TO: Jeff Watson, Community Development Services  
FROM: Christina Wollman, Planner II *CW*  
DATE: October 23, 2013  
SUBJECT: Taylor BL-13-00024

The Public Works Department has reviewed the Request for Boundary Line Adjustment Application. In order to ensure that it meets current Kittitas County Road Standards, the applicant needs to provide the following prior to final approval:

K.C.S.P. NO. 06-90
Portion of the NW1/4, Sec. 31 T.20N., R.17E., W.M.
Kittitas County, Washington

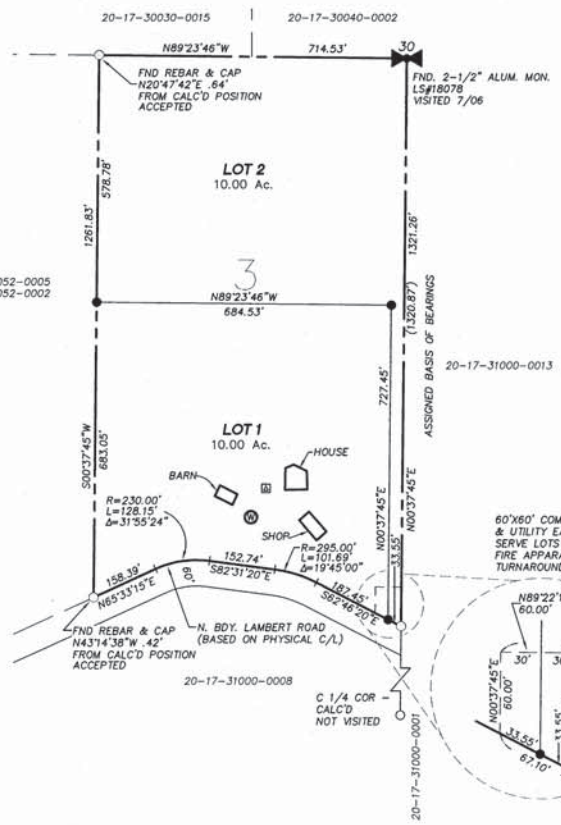
1. A revised legal description that describes the final configuration of the subject property shall be required.
2. The 60' X 60' easement shall be moved to the western property line with the new access to Lot 2.
3. A variance was granted to this property to allow reduced road standards. The road improvements on Lambert Road shall extend to the western property line to the new entrance to Lot 2. An additional turnout may be required. This requirement shall be determined by the Fire Marshal.
